RE: Brownlee SP-16-00004 Comment

My wife and I are adjacent neighbors (directly to the east) of the Brownlee Short Plat proposal. We believe that the applicant has not taken into consideration the following; General statement, water & access.

BROWNLEE SHORT PLAT
PART OF SECTION 36, T. 17 N., R. 19 E., W.M.
KITITAS COUNTY, WASHINGTON

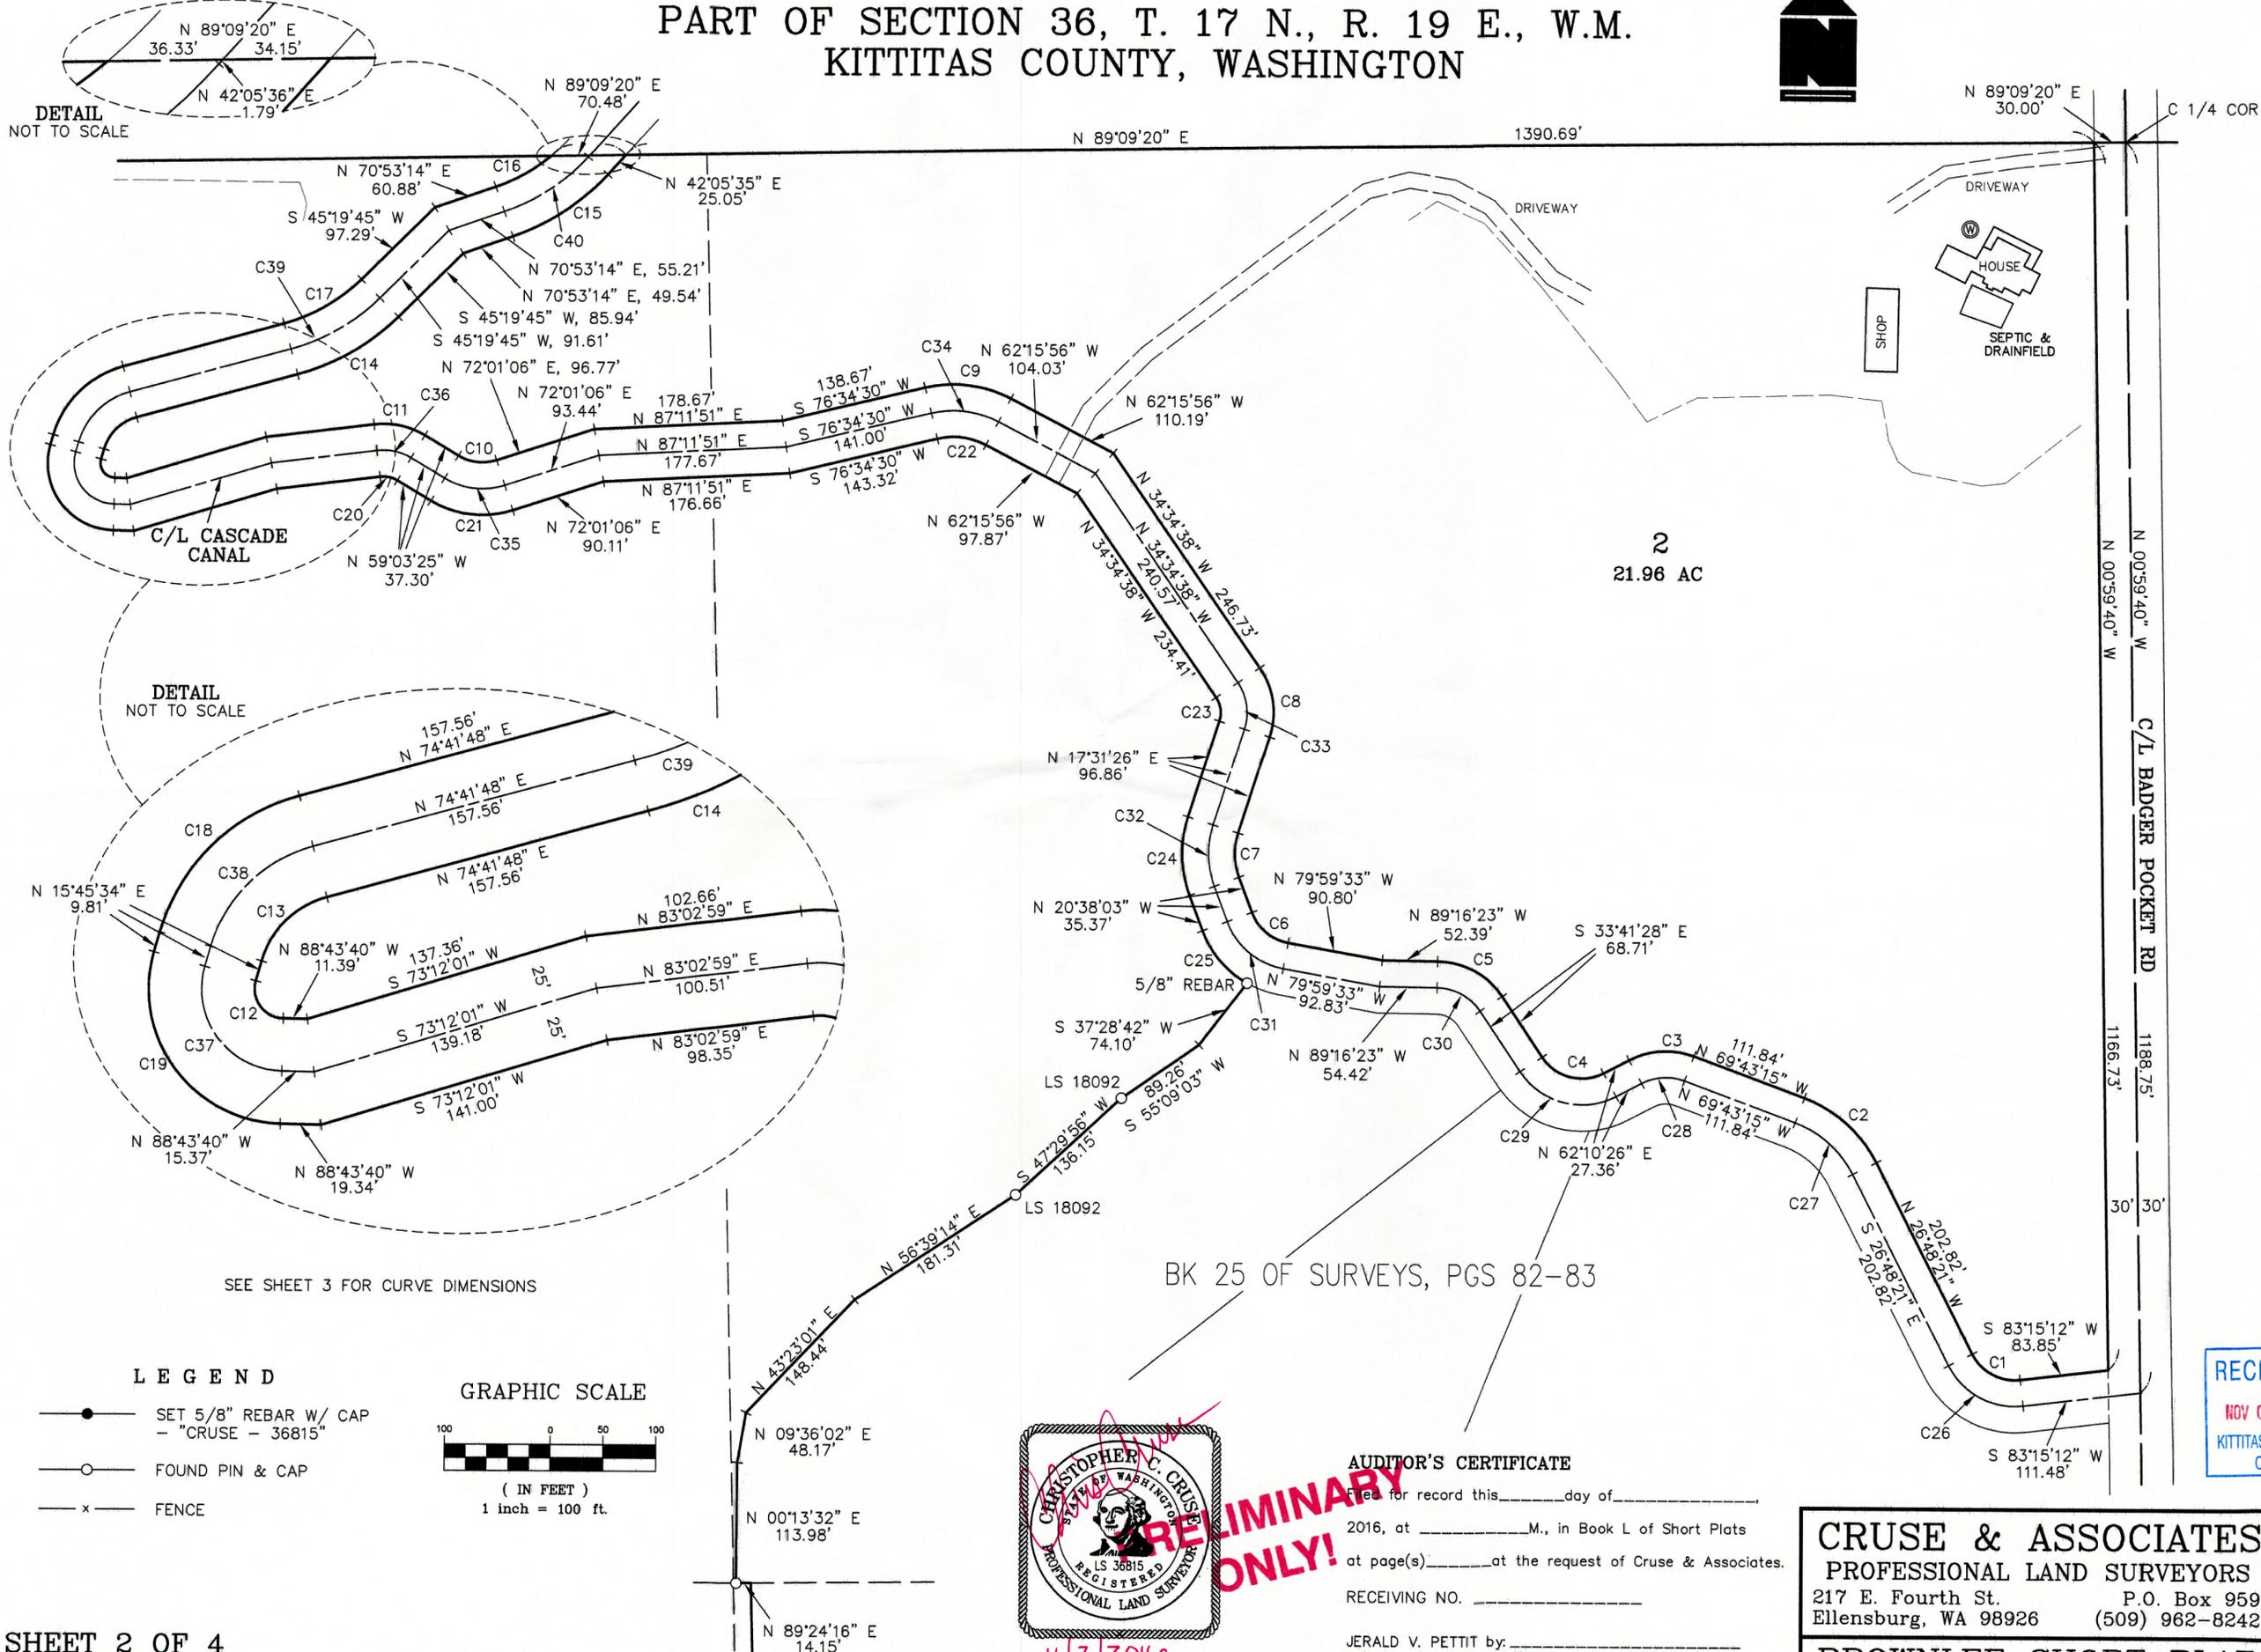
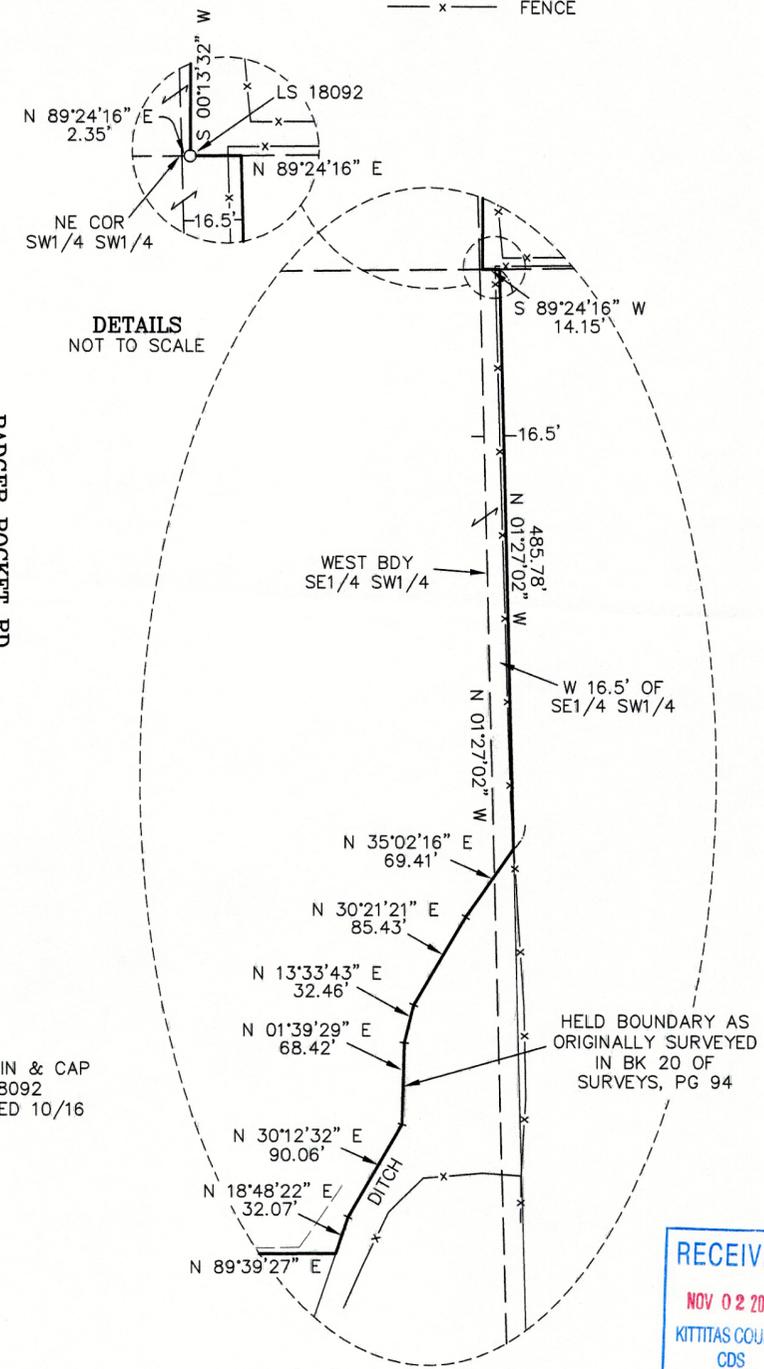
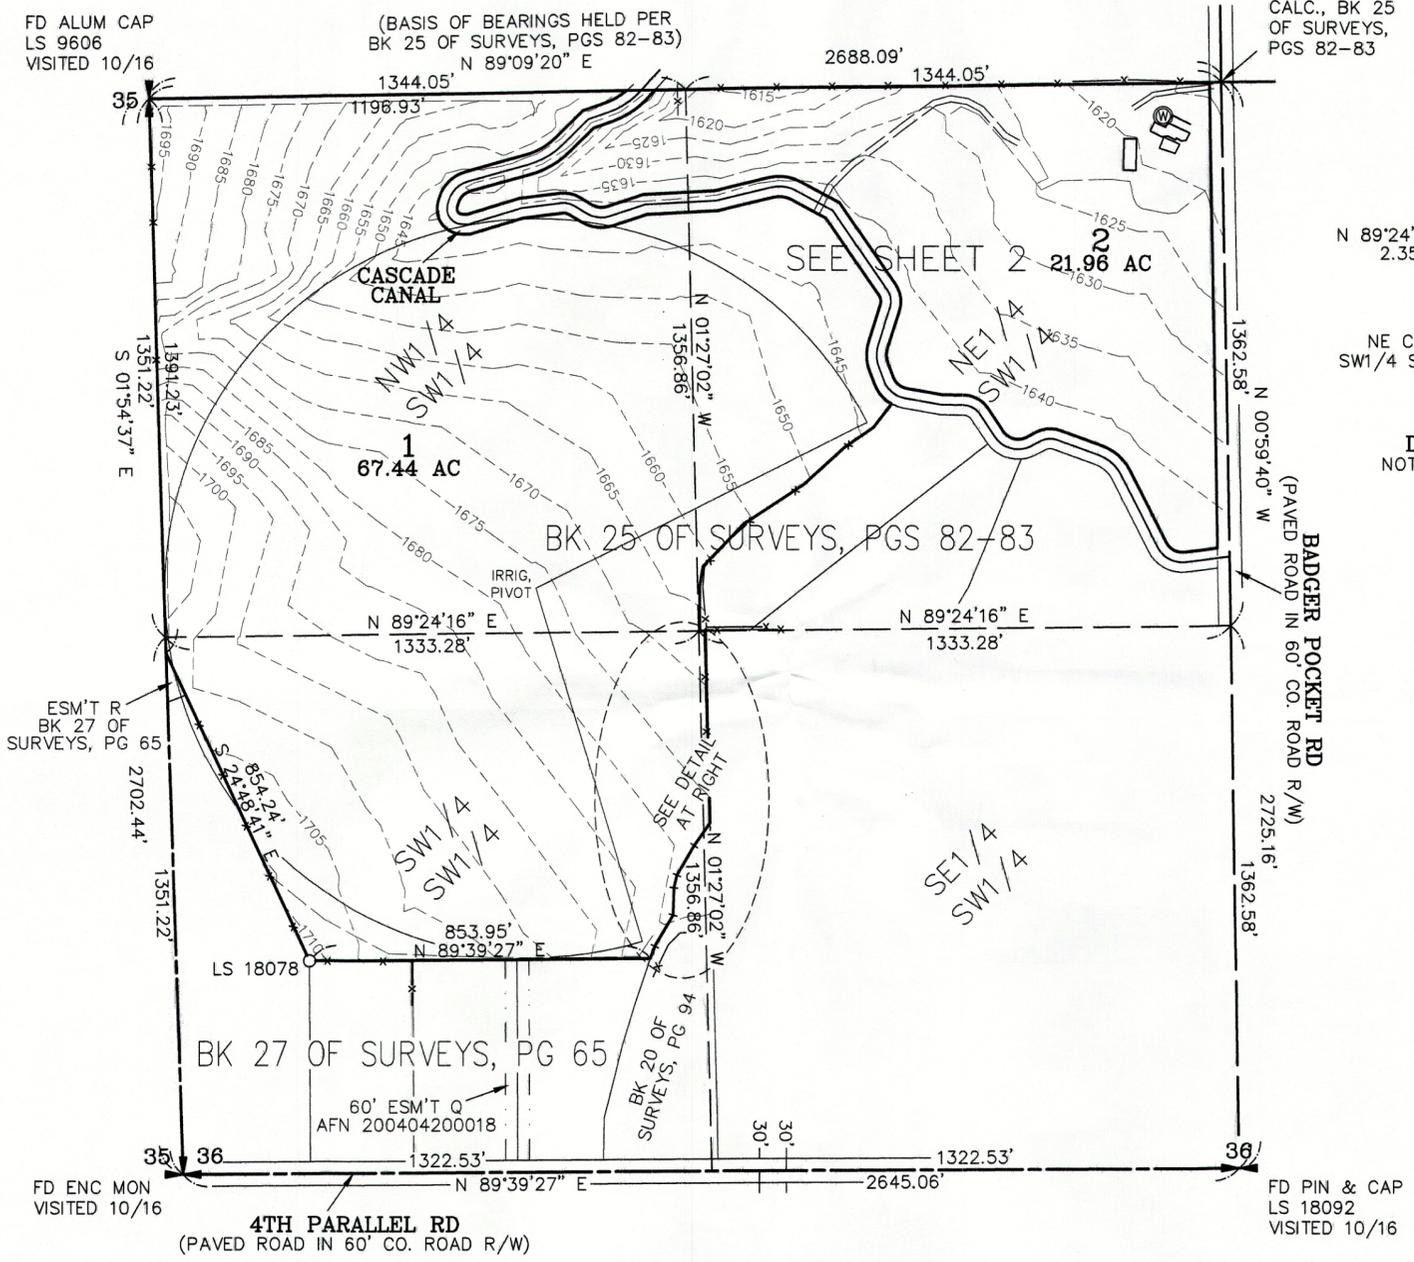
There is no supporting evidence provided by the applicant on how this subdivision does or does not affect senior water right holders in the area, specifically Cascade Irrigation District canal, which runs through the property.

There is not an irrigation distribution plan approved or approval in the file by the irrigation district meeting the County Code requirement?

The access to Lot 1 seems to be through an agricultural easement (Rec. # 200404200018). This easement, within the title report, states it is an agricultural easement. We specifically request that if this proposal goes through that this access stays an Agricultural easement and not an access for a single-family residence. This will guarantee that the existing easement stays true to the intent and that another home will not be allowed on Commercial Agricultural ground therefore further protecting commercial ag. resource lands and not creating additional rural sprawl and loss of Commercial Ag Resource lands.
